### Application for Removal or Variation of a Condition following Grant of Planning Permission or Listed Building Consent

Demolition of garden room and erection of a two storey rear extension, fenestration alterations and replacement garage

23/01350/HOU

Condition 2 approved drawings  
Condition 6 window details

Drwg No. 2359/05

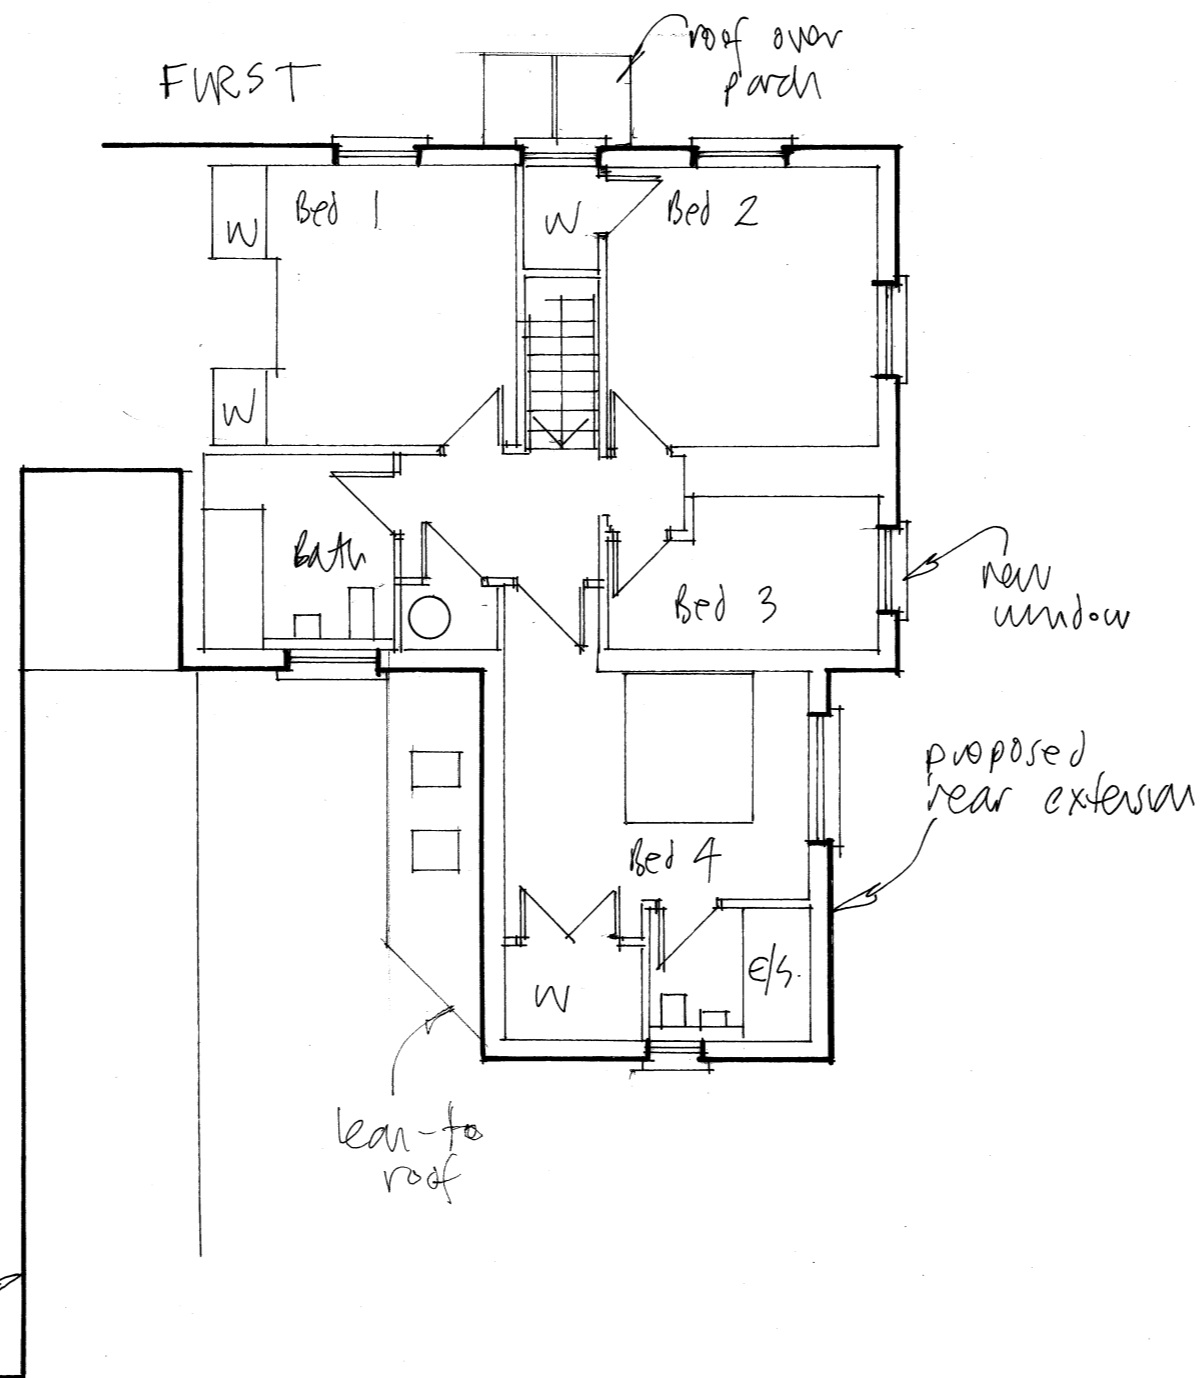
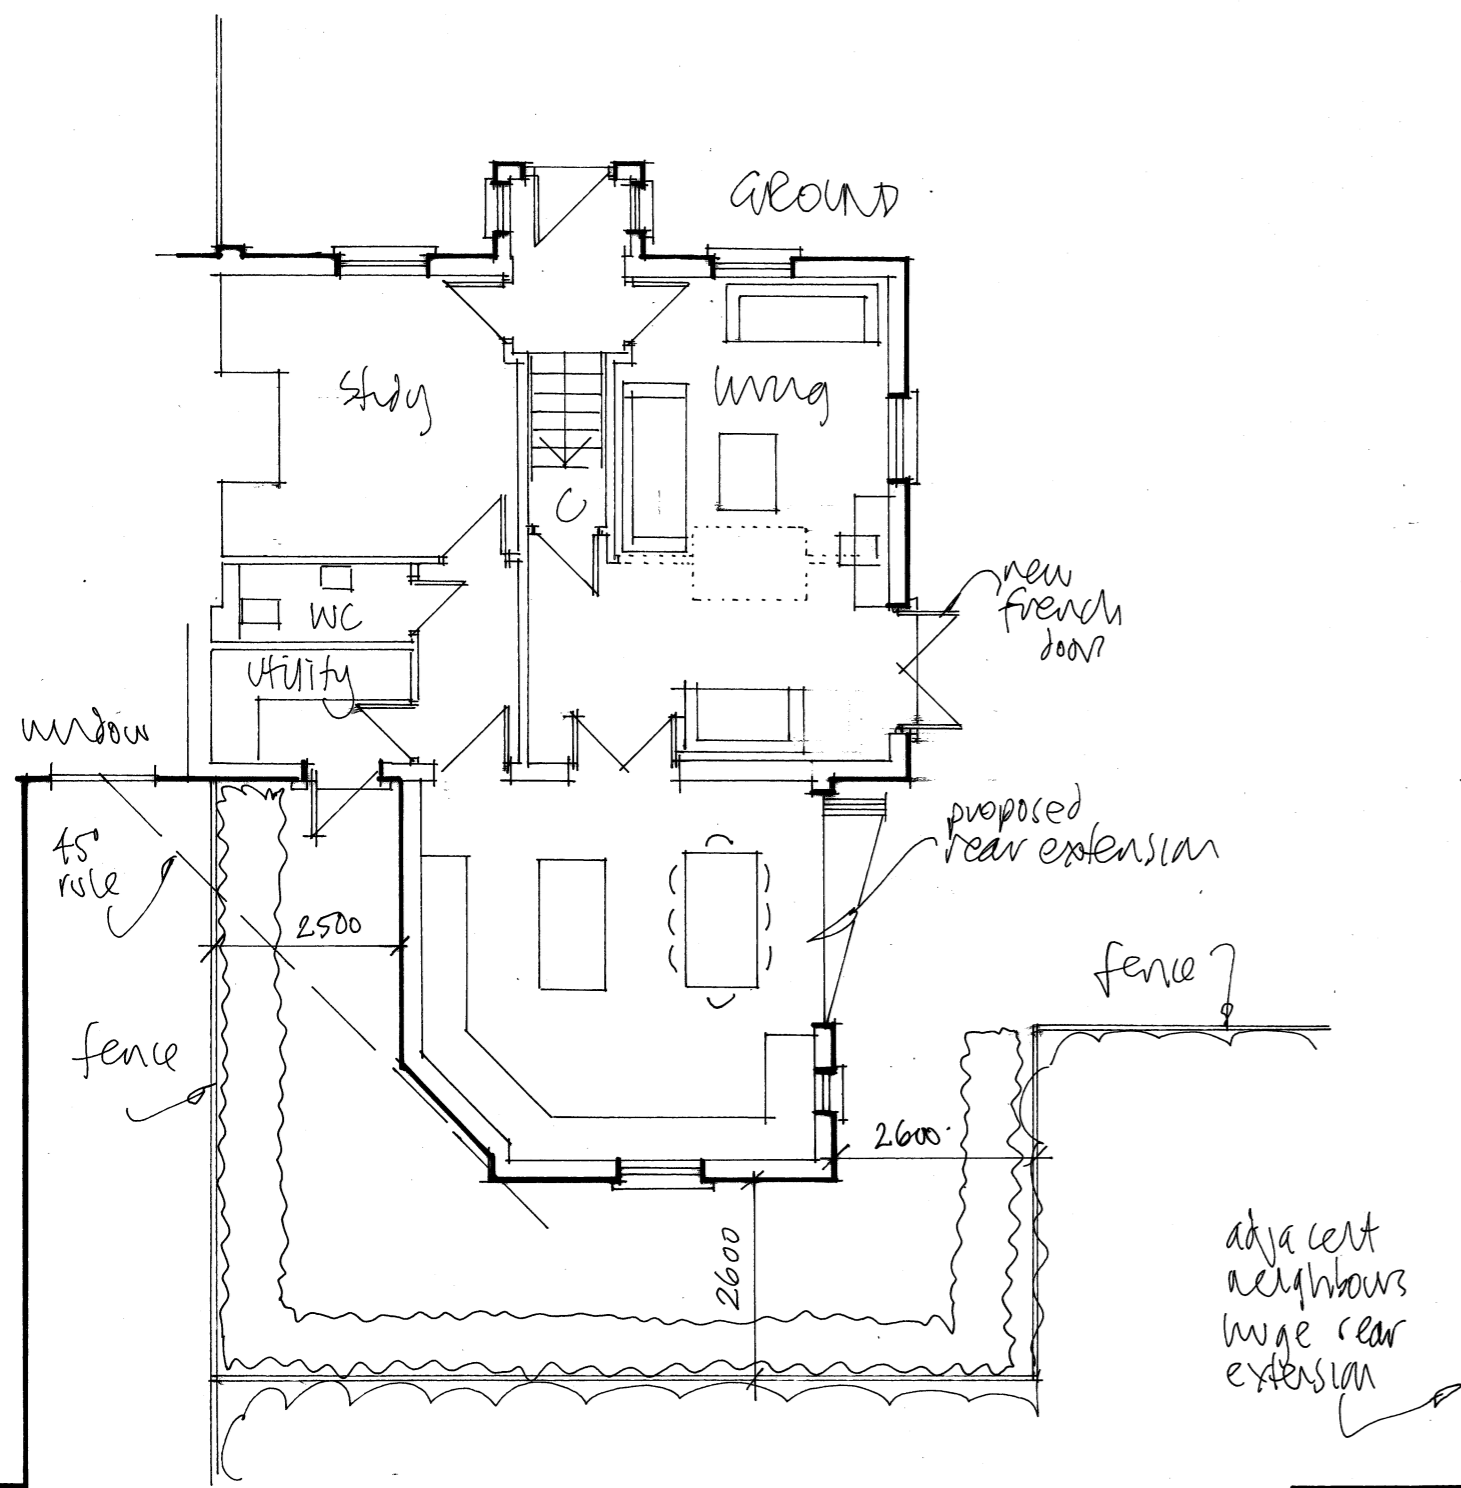
Change in specification of proposed replacement sash windows from slim timber joinery, to slim, timber effect upvc components. Change is requested due to noise levels from main road - the upvc system provides a better sound reduction value and better overall thermal performance.

Condition 2 approved drawing references changed from 2359/05B to 2359/05D and 2359/08A to 2359/08B

Condition 6 wording amended from 'the windows hereby permitted shall consist of slimlite units and timber frames and through glazing bars' to 'the windows hereby approved shall consist of slimlite units with timber effect slim upvc frames and glazing bars'.
